Application No: AW/100/20/HH
Site Address: Southgate Lincoln Avenue Aldwick PO21 3EJ
Description of works: Loft conversion with hip to gable extension & dormer, single storey rear & side extension & render & cladding to extension.

Thank you for your internet representation made on 15th May 2020 which has been recorded as no objection with the comments as follows:

SITE PLAN
PROPOSED
1:250 @ A1

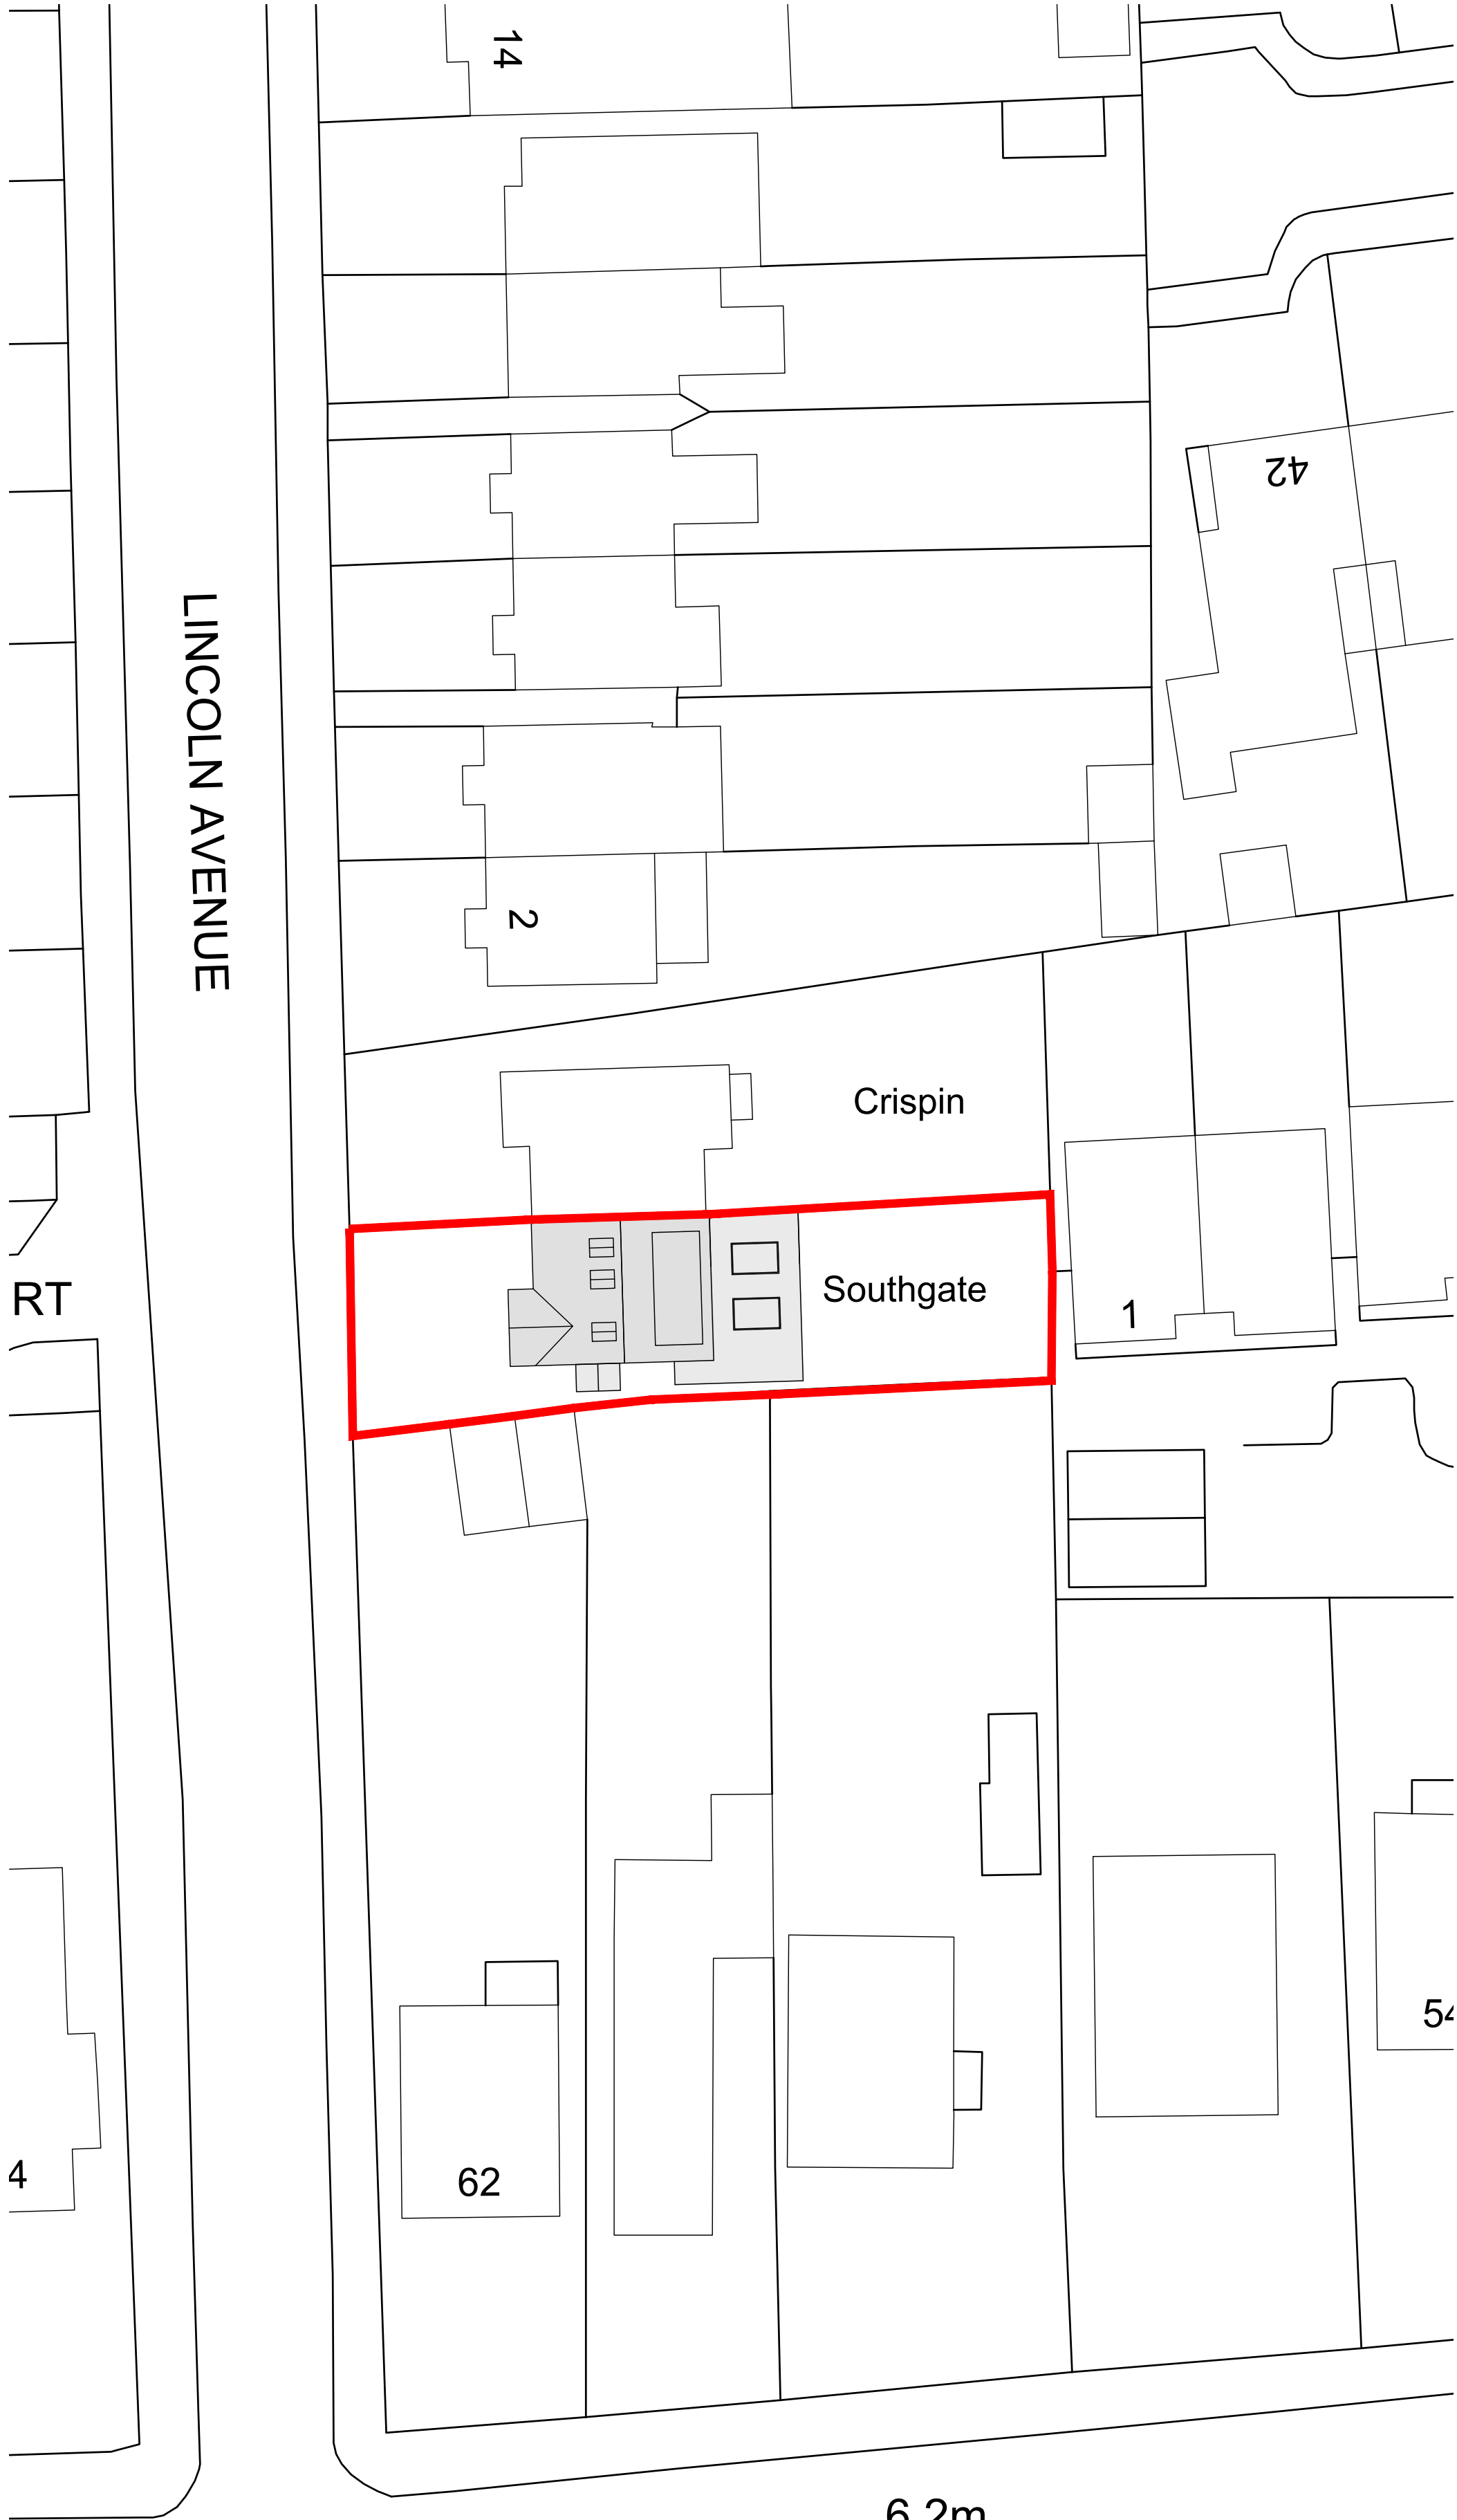
I would question the ability to construct/ access and maintain the extension on the Northern side due to the extremity of construction to the Party Wall/ Fence line.

Recommend moving the building line to allow maintenance and building.

ROOF PLAN
PROPOSED
1:50 @ A1

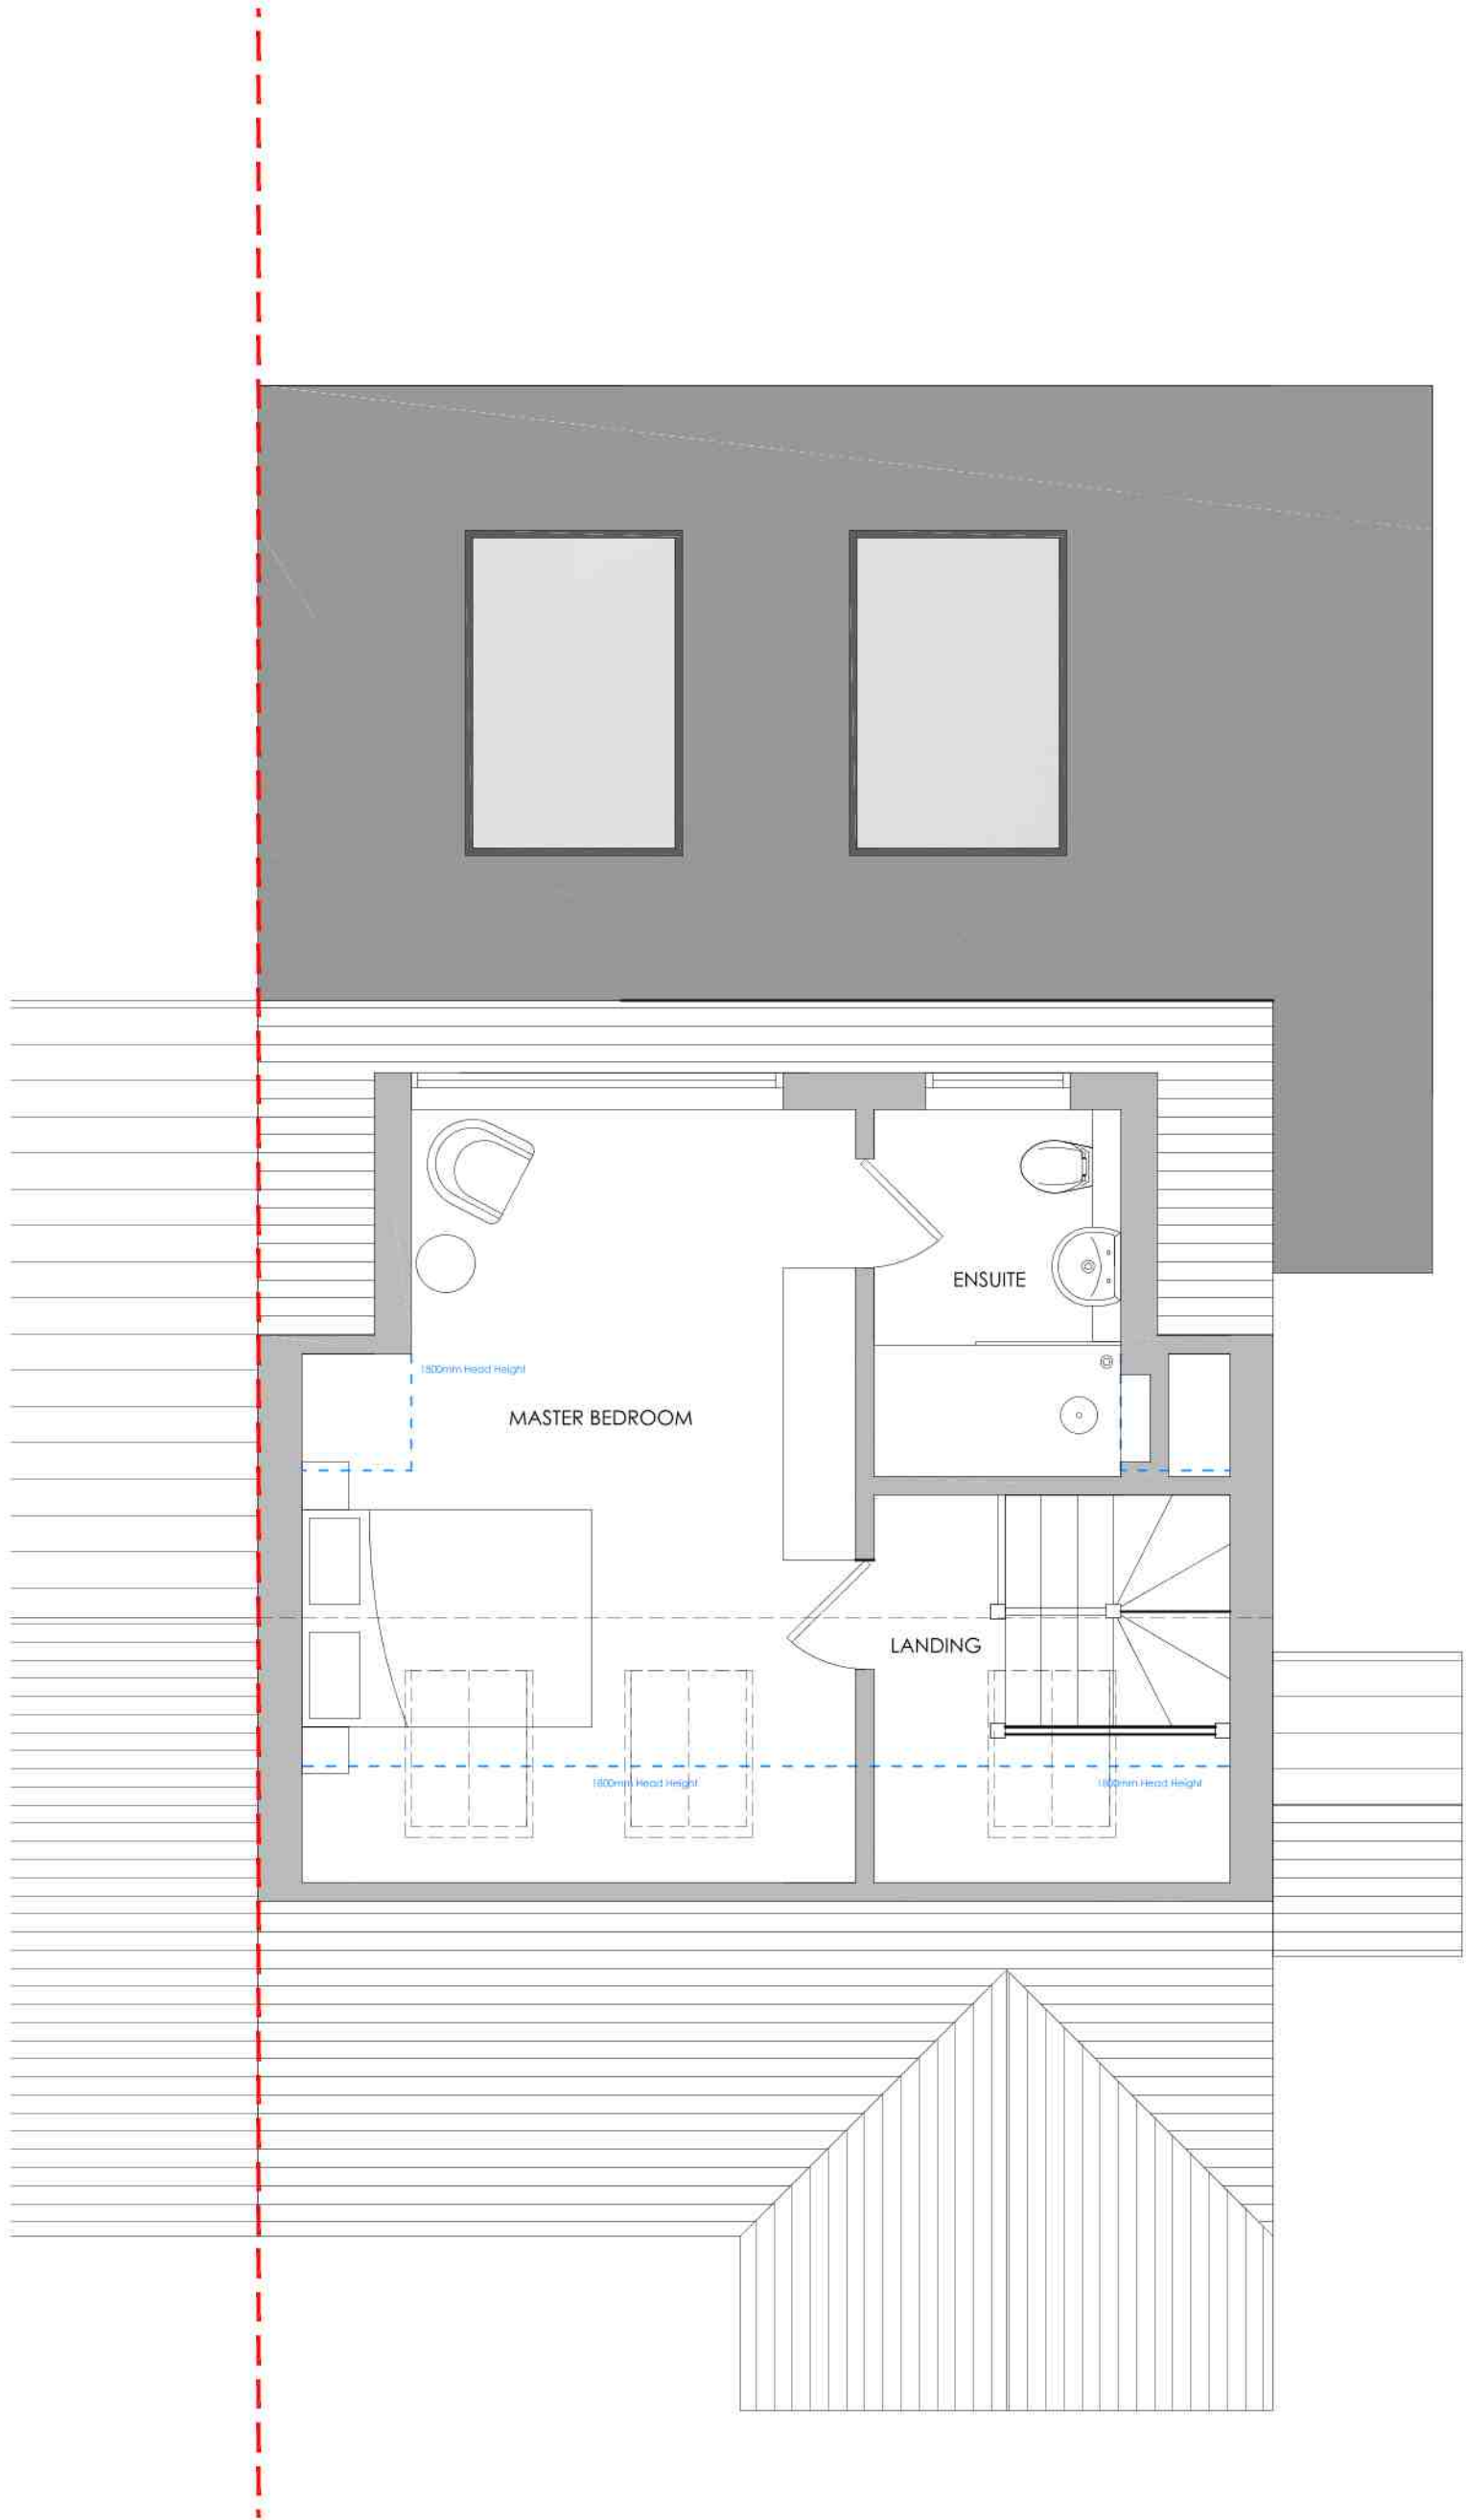
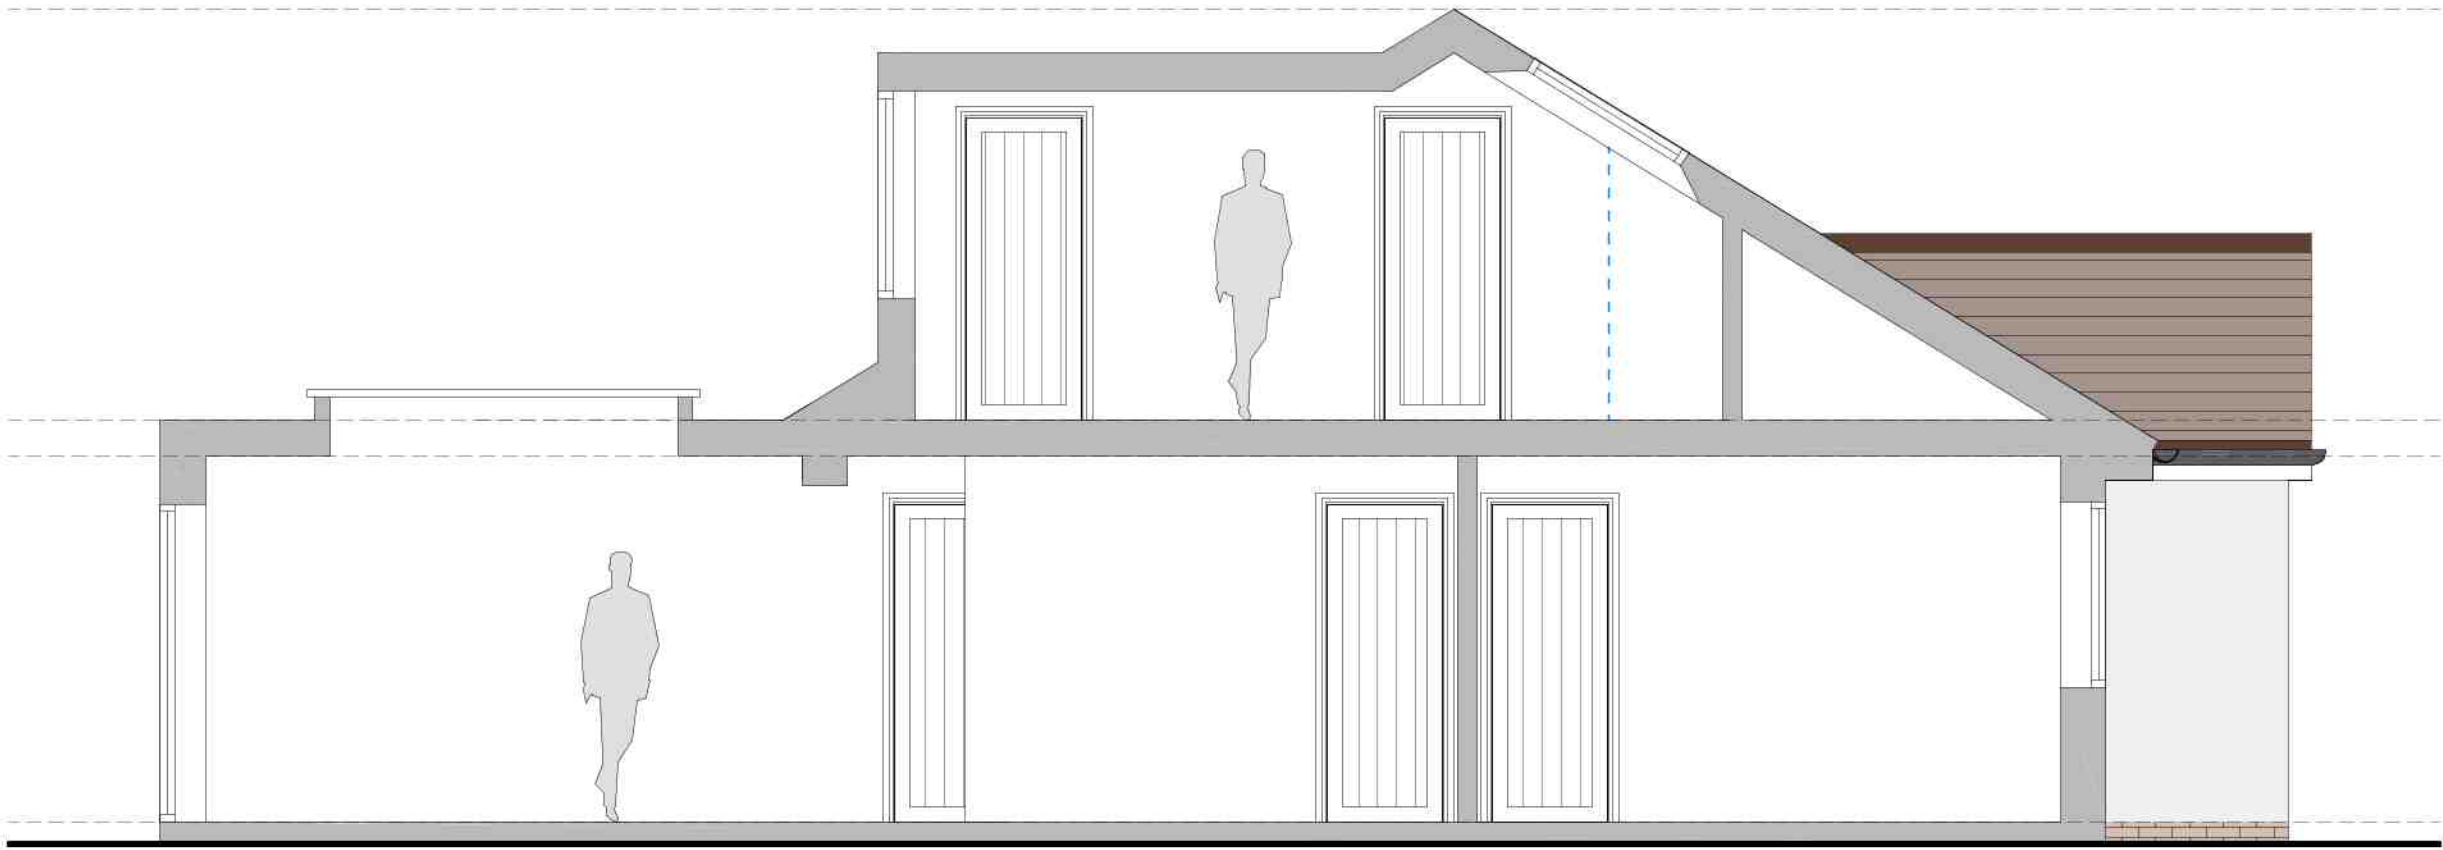
Boiler Flue to the adjoining property exists at roof level and currently would be close to the proposed dormer windows, this will have to be extended/ moved.
